Objection to the State Significant Development Application for a Mixed-Use Development at 270 Pacific Highway, Crows Nest (SSD-79658964)

This submission is made in objection to the State Significant Development Application (SSDA) for a 16-storey mixed-use development at 270 Pacific Highway, Crows Nest.

TREE CANOPY COVERAGE | TARGETS AND PLAN

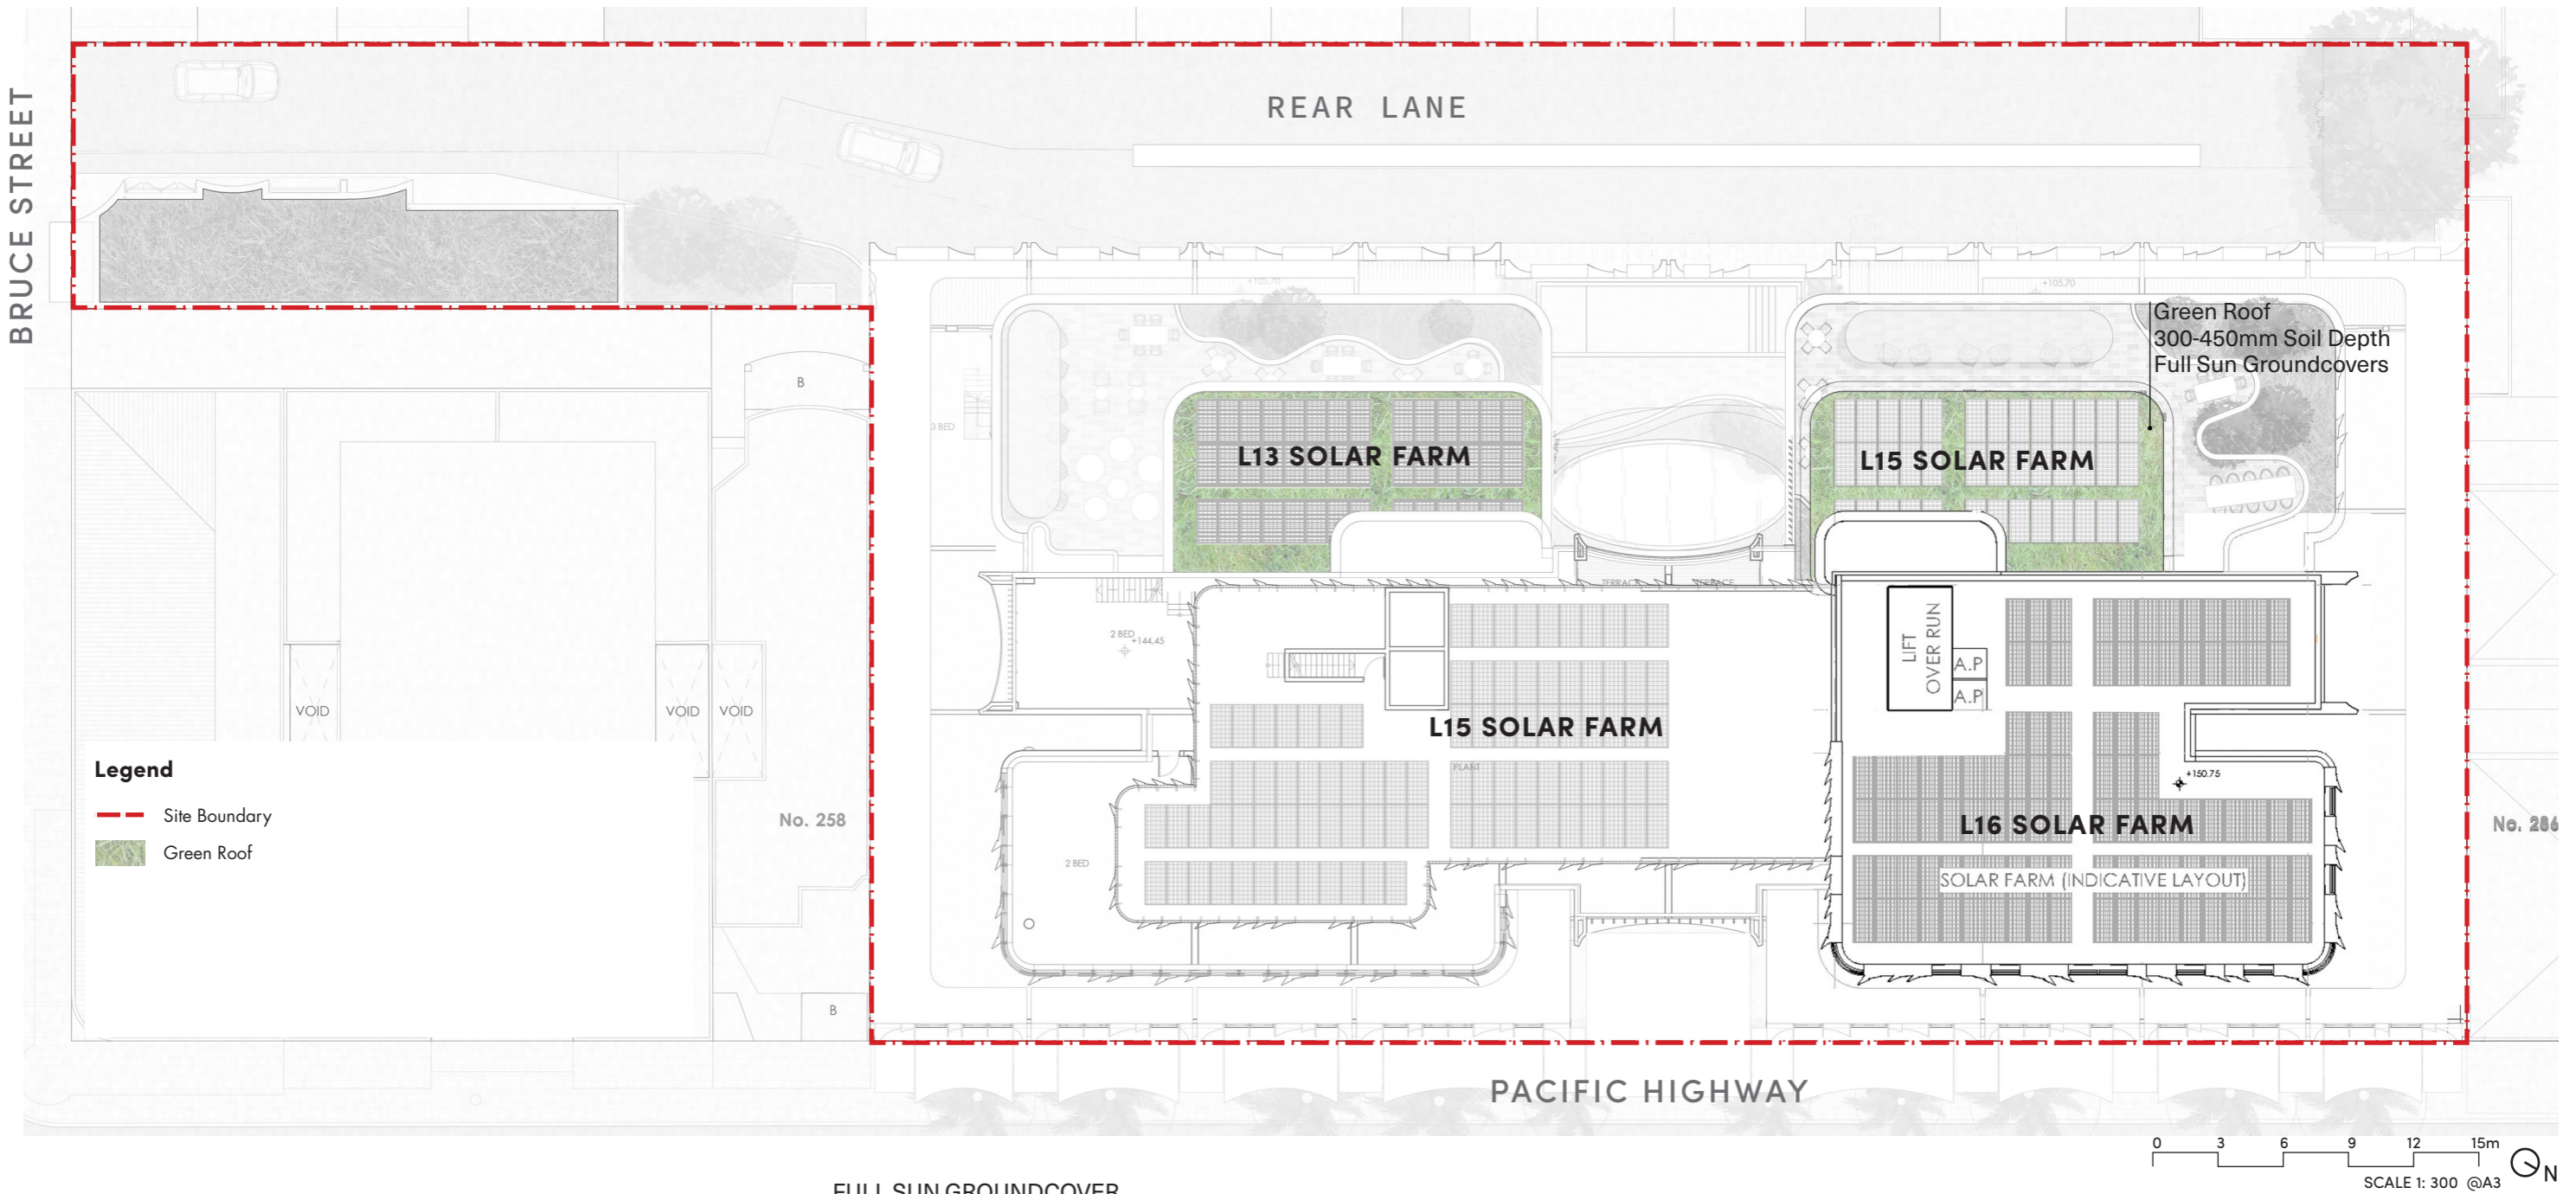
- **Significant Shortfall in Tree Canopy Provision:** The *Landscape Report* shows the proposal will achieve only 5% tree canopy cover. This is a significant shortfall when compared to the 15% canopy cover target for the area set by the *North Sydney Council Urban Forest Strategy 2019*. The application fails to adequately pursue a design that meets this important local environmental goal.

# Solar Access

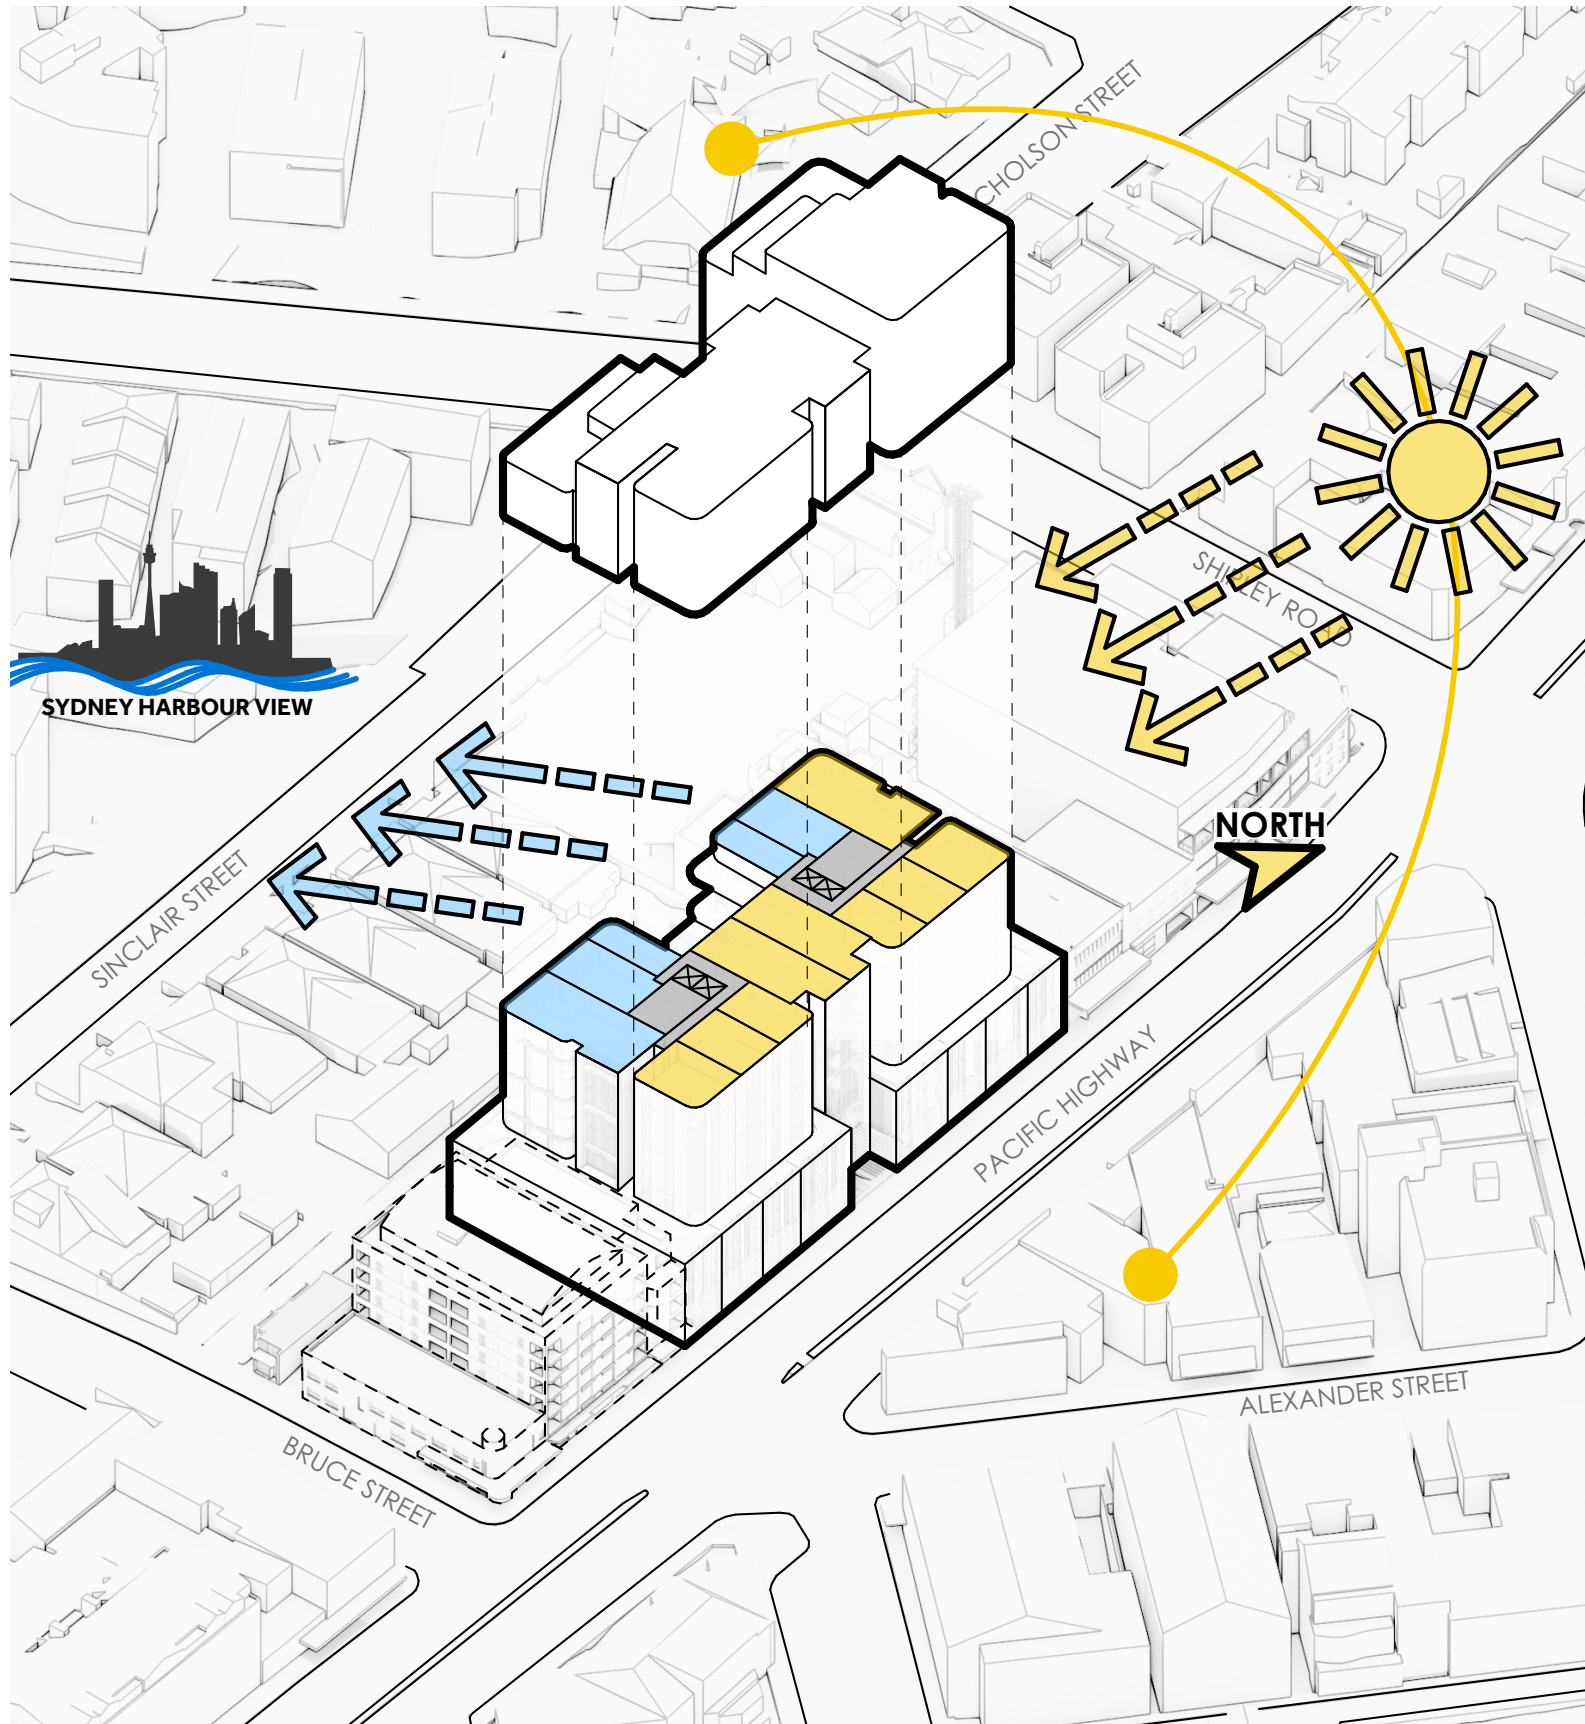
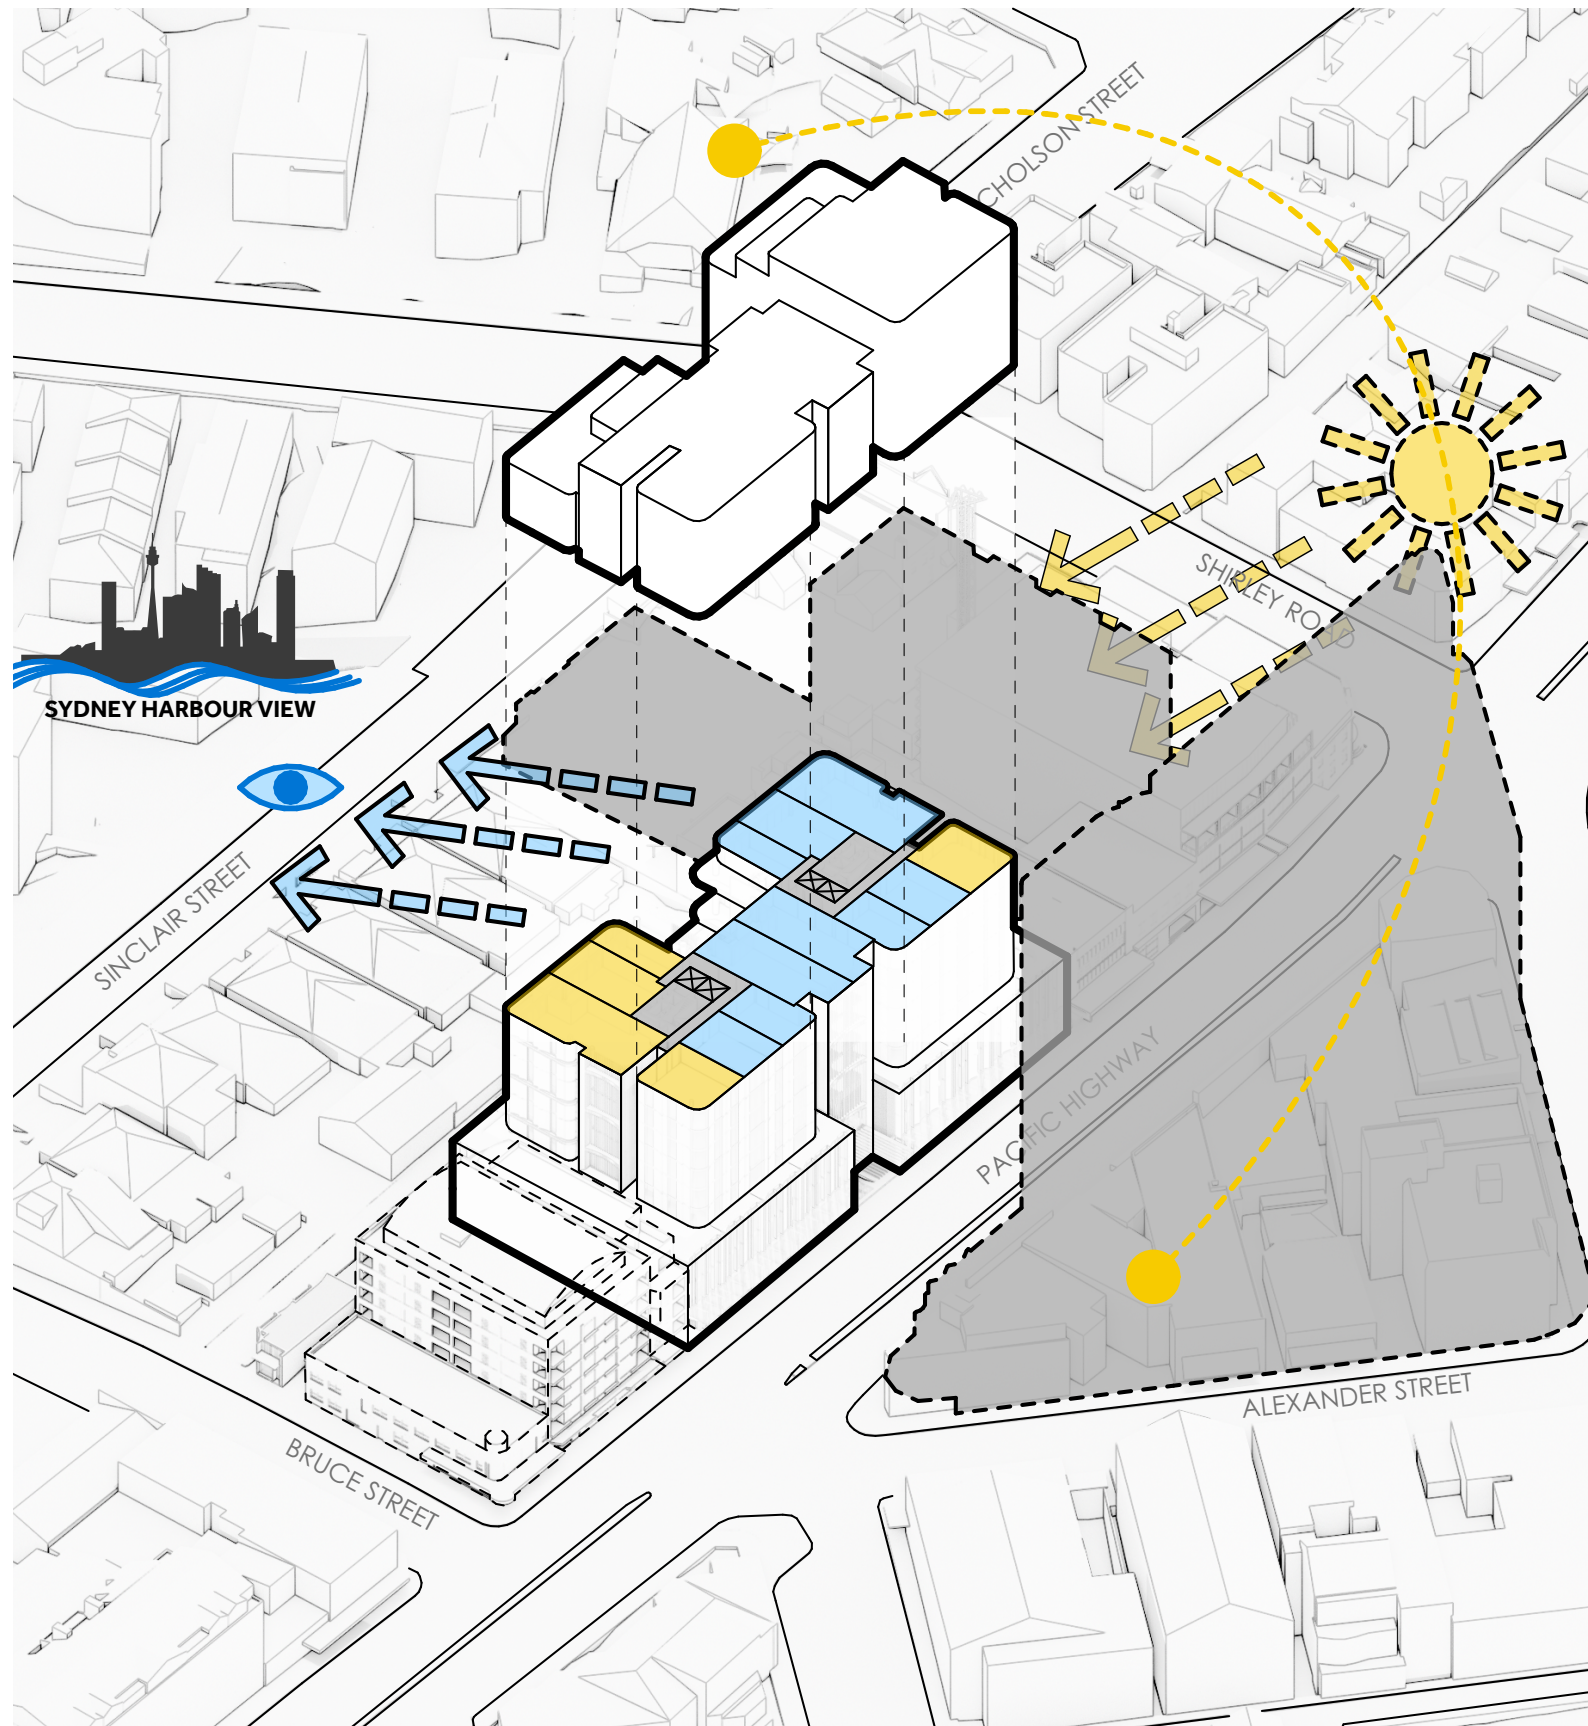
- **Unjustified Departure from Solar Access Standards:** The proposal acknowledges that only 19% of apartments will receive the minimum two hours of direct sunlight in mid-winter, a major departure from the 70% benchmark in the Apartment Design Guide (ADG). The justification - relying on flexibility for BTR projects and providing more communal open space - is underdeveloped given the sheer scale of the non-compliance. This represents a poor amenity outcome for a significant majority of future residents.
